## **M25 junction 28 improvement scheme**

### **9.71 Applicant's response to A Manley's written summary of hearings**

#### 9.71 Applicant's response to A Manley's written summary of hearings

## 2. REP4-032 - ANTHONY MANLEY DEADLINE 4 WRITTEN SUMMARY OF ORAL SUBMISSIONS AT HEARINGS HELD WEEK COMMENCING 1 MARCH 2021

Drawing Title: **TEMPORARY TRAFFIC MANAGEMENT
A12 EASTBOUND ON SLIP ROAD CLOSURE
DIVERSION ROUTE**

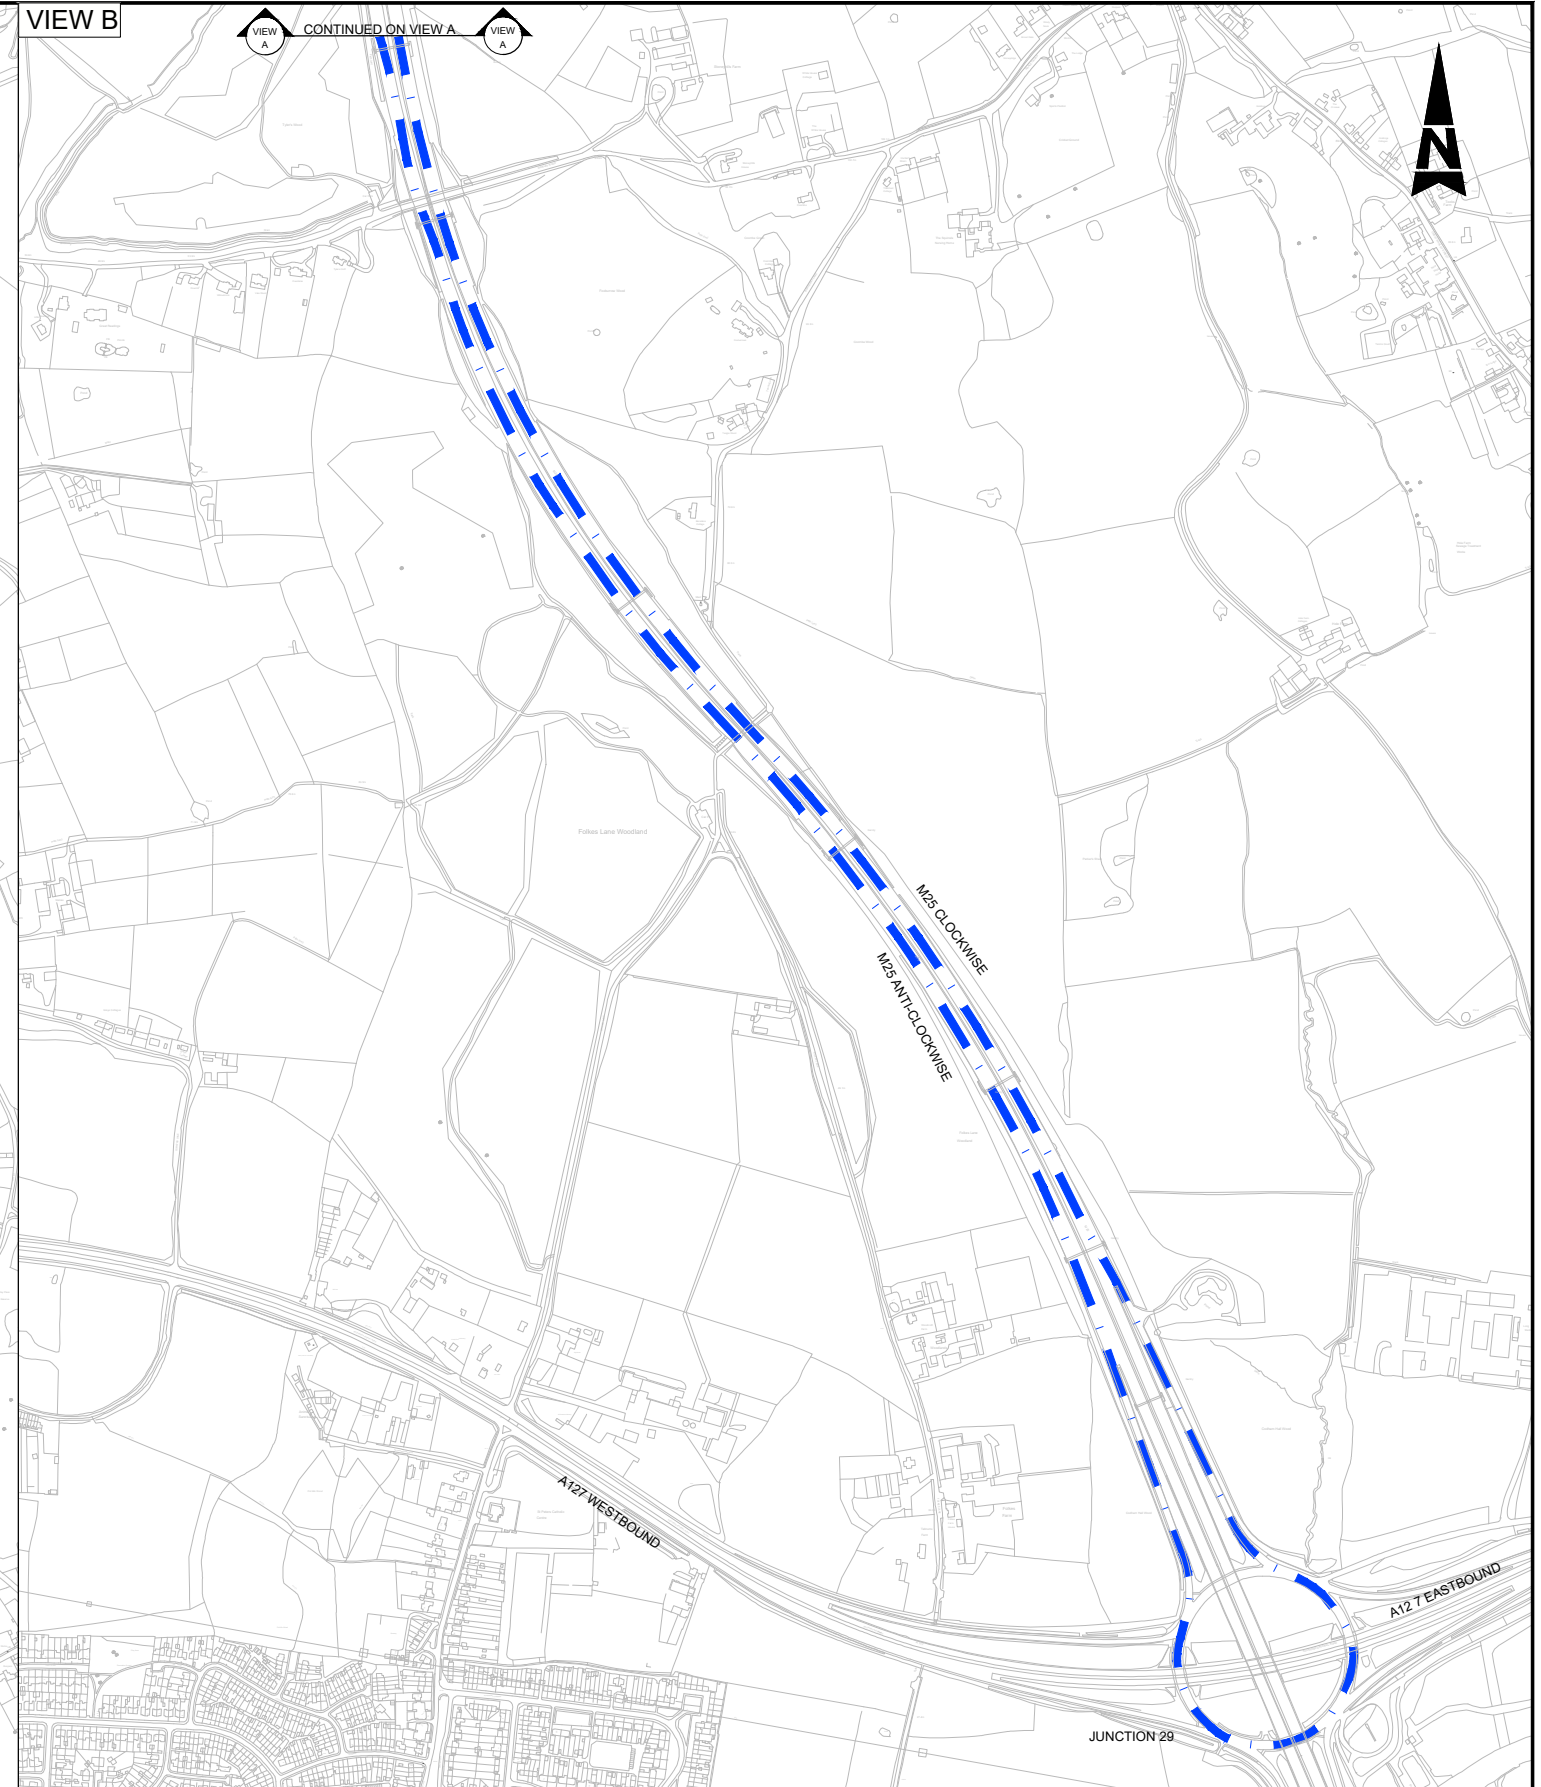
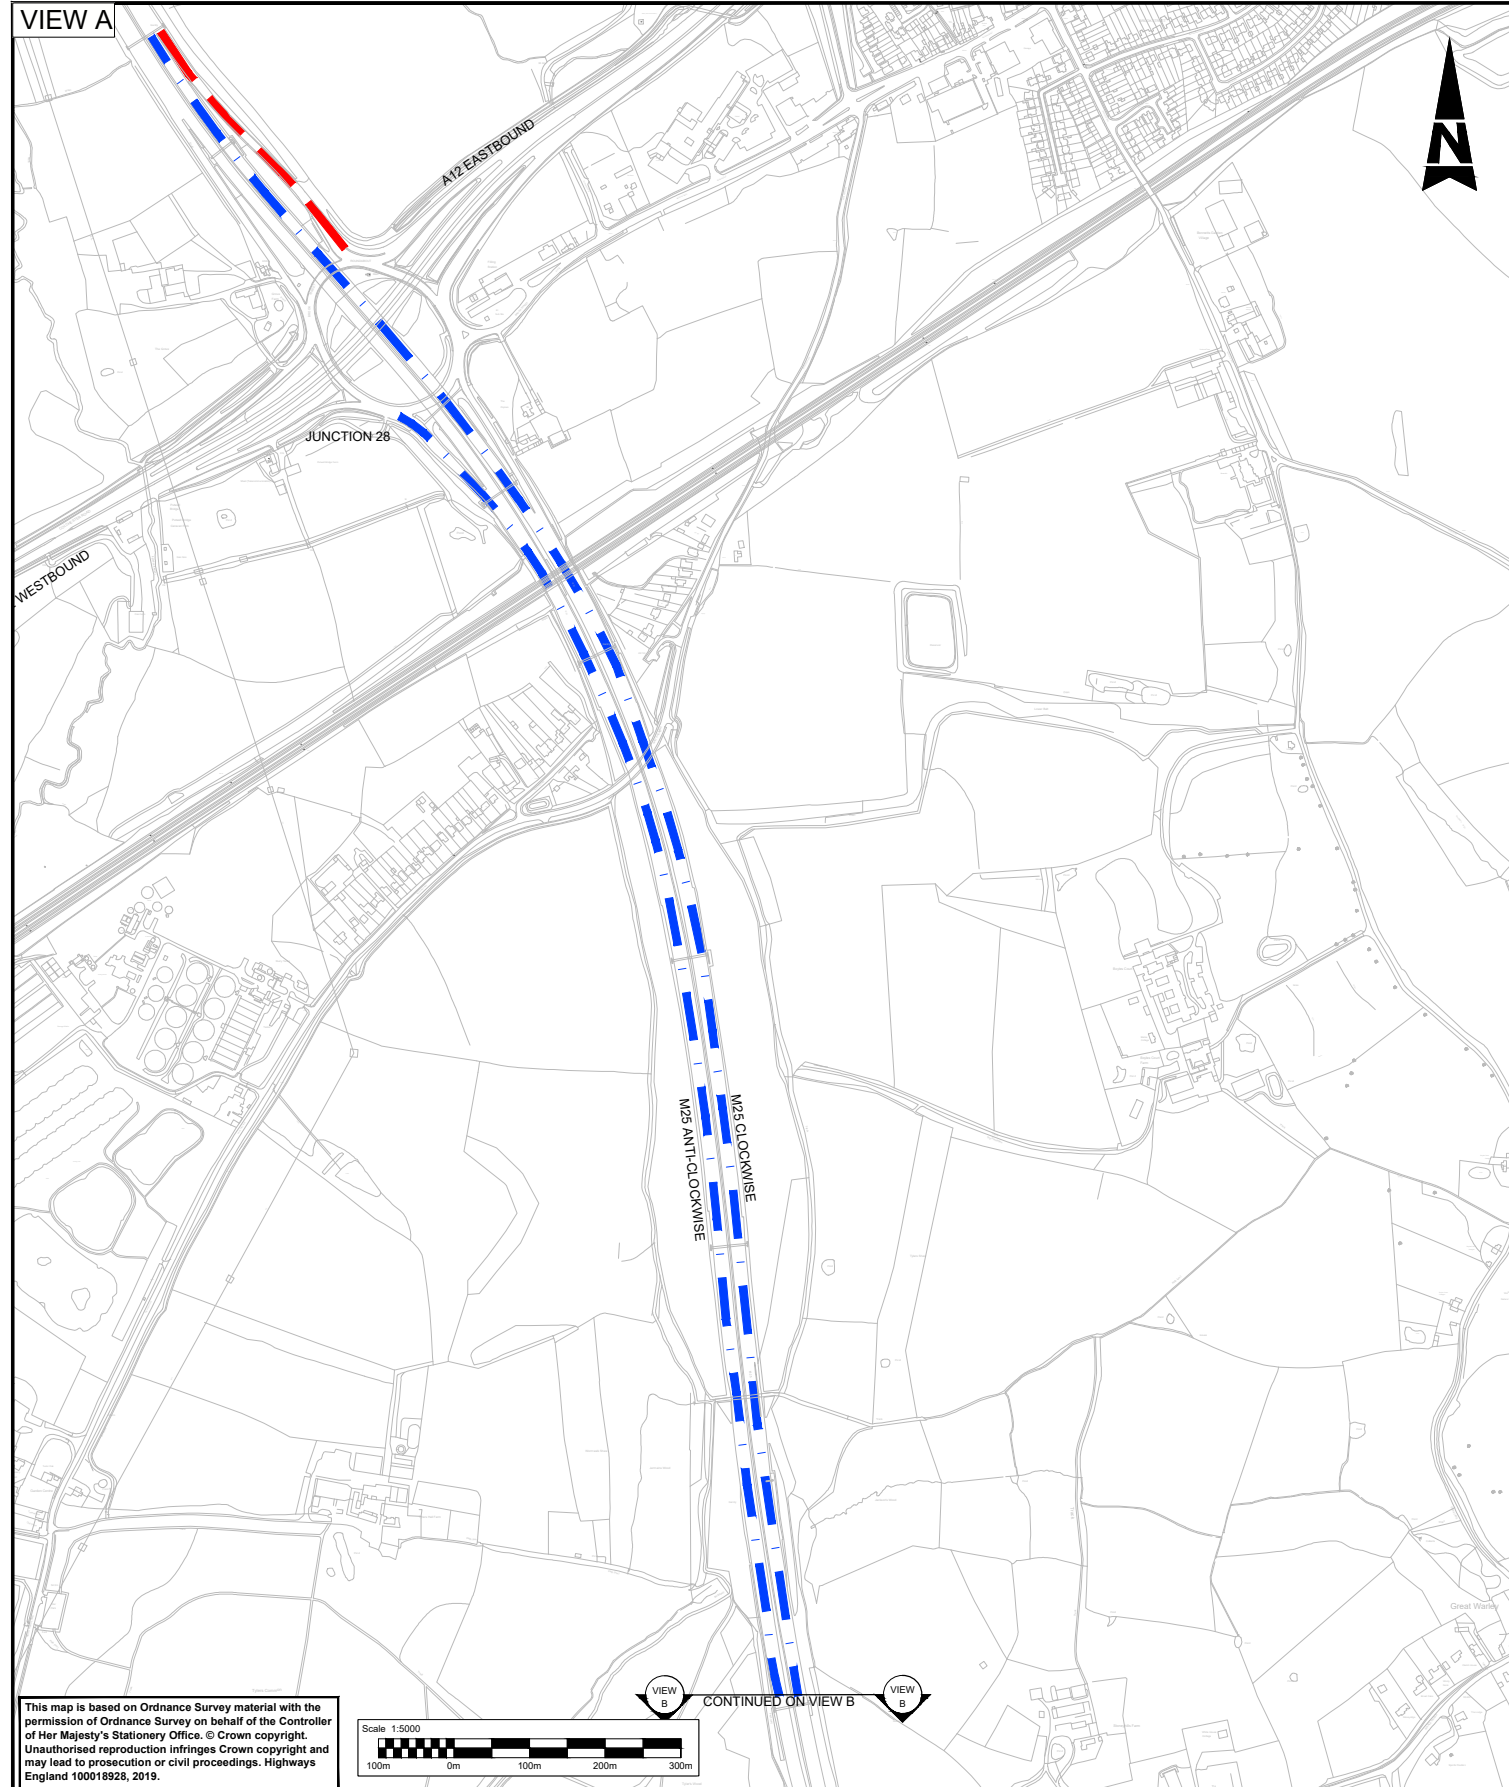
Response reference:	Representation Issue	Highways England Response
REP4-032-01	<p>It would be very helpful if a proviso was put in place within the planned works, before the inevitable traffic delays occur during construction, to include a U-Turn on the A12, with a traffic light control. This could be placed anywhere between Woodstock Avenue and the exit slip road off the A12 Eastbound to take the pressure off Brook street junction and avoid the diversion whenever the exit is closed. All residents who live in Woodstock and Kenilworth Avenues that have to travel Westbound will then avoid the minimum of a 12 mile diversion. Every day at peak times heavy traffic builds up from the slip road junction A12/M25 (travelling west bound) which would make the diversion a complete nightmare because journey times would exceed an hour just to return to the opposite side of our road along the A12 where it started.</p>	<p>The option of installing a U-Turn as part of the Scheme, with a traffic light control, on the A12 between Woodstock Avenue and the exit slip road is outside the scope of the Scheme and would need to be considered by Transport for London (TfL) as the highway authority for this section of the A12.</p> <p>Please refer to paragraphs 7.8 to 7.10 of TfL's Written Representation (REP2-036) and TfL's response to Written Question TA1.13 (REP2-037) which explains that TfL, as the highway authority for the A12, does not support the provision of a permanent right turn from Woodstock Avenue because it has concerns about the feasibility of designing a safe junction and the disruption such a junction would cause to a greater number of road users on the A12. Highways England expects that a temporary U-turn on the A12 would pose similar safety risks.</p> <p>Temporary traffic management arrangements required to construct the Scheme will inevitably result in some temporary additional traffic congestion and delay. However, there will only be a few overnight occasions when the U-turn from the A12 eastbound off-slip to the A12 westbound at junction 28 will not be permitted and a temporary signposted alternative diversion route put in place. To minimise disruption, full closure of the A12</p>

Response reference:	Representation Issue	Highways England Response
		<p>eastbound off-slip would only take place overnight when there would be much less traffic on the road network and delays to journey times therefore kept to acceptable levels. The diversion route for occasional overnight closures of the A12 eastbound off-slip will be via the Mountnessing junction on the A12 to the east, which will add approximately 10 to 15 minutes to journeys that would otherwise U-turn at junction 28 to head west on the A12.</p>
<p>REP4-032-02</p>	<p>I also want to know how the noise levels are going to be managed late at night during slip road closures? Highways England stated at the first meeting that heavy equipment will be moving around and bright flood lights used, for up to 3 years as forecast. This will impact all residents of Woodstock Avenue. We are already affected by the noise from vehicles travelling on the motorway day and night and in particular when the wind is blowing from the East which is most of the time.</p>	<p>Highways England has provided a response to this issue in its response to Mr Manley's Relevant Representation (RR-003-1) set out in Highways England's responses to Relevant Representations (REP1-002).</p> <p>As described in section 6.9 of the Environmental Statement (ES) Chapter 6 Noise and vibration (REP3A-006), night-time works will be avoided as far as reasonably practicable however, night-time works will be required on the existing highway network when the new road infrastructure needs to be tied in to the existing road infrastructure. It is anticipated that these activities will be undertaken between 23.00 and 07.00. These activities are likely to include installing traffic management, and various construction activities such as: working on the gantries, road surfacing, white lining, and constructing the tie ins to the existing network. The Principal Contractor will apply for a Section 61 consent under the Control of Pollution Act 1974 for some construction works, and any night-time works. This would be discussed when engaging with the local authorities prior to works commencing and include</p>
